CITY OF PORTLAND, MAINE
DEVELOPMENT REVIEW APPLICATION
PLANNING DEPARTMENT PROCESSING FORM

Ruby Lane #14

65 - 65 Ruby Ln, Portland, Maine

RE: Application for Single Family Residences, Ruby Lane lots #13 and lot #14

LOT 14 GRADING & EROSION
 CONTROL PLAN

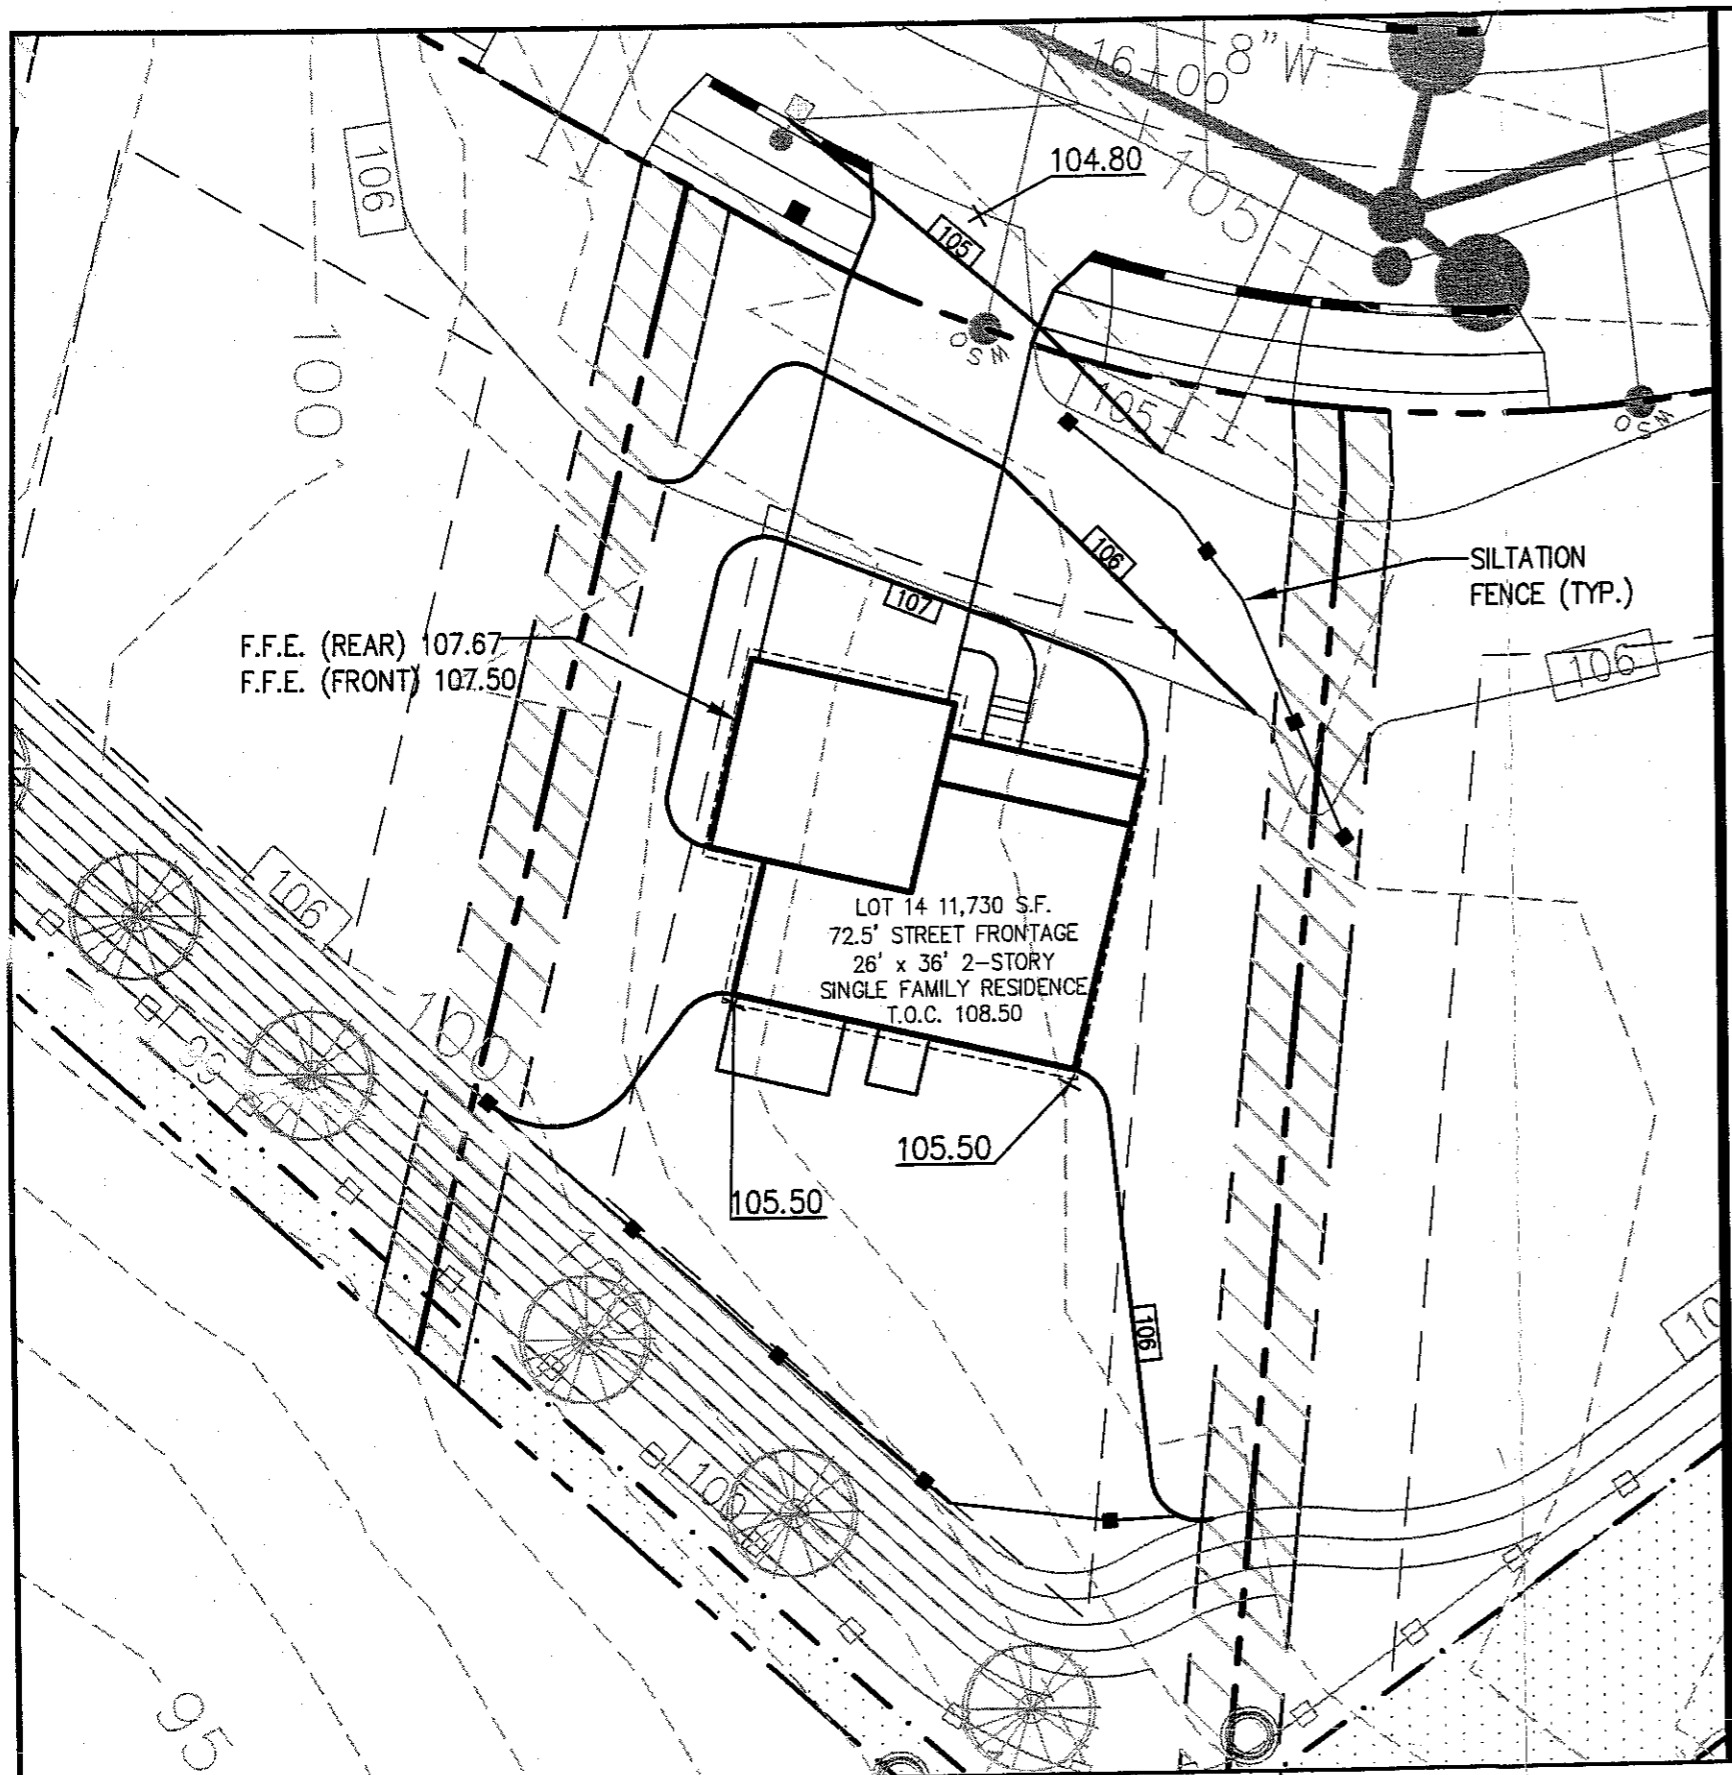
1. Street tree shown over the utilities needs to be moved.
2. The topography and spot grades indicate that the rear yard will be pitched towards the building. Please correct.
3. Please label the no-cut/undisturb zone along the rear property line.
4. The curb cut on your plan does not match the curb cut location on the approved subdivision plans. Please clarify.

1. Please add two street trees to your plan.
2. Same items listed above (2., 3., and 4.).
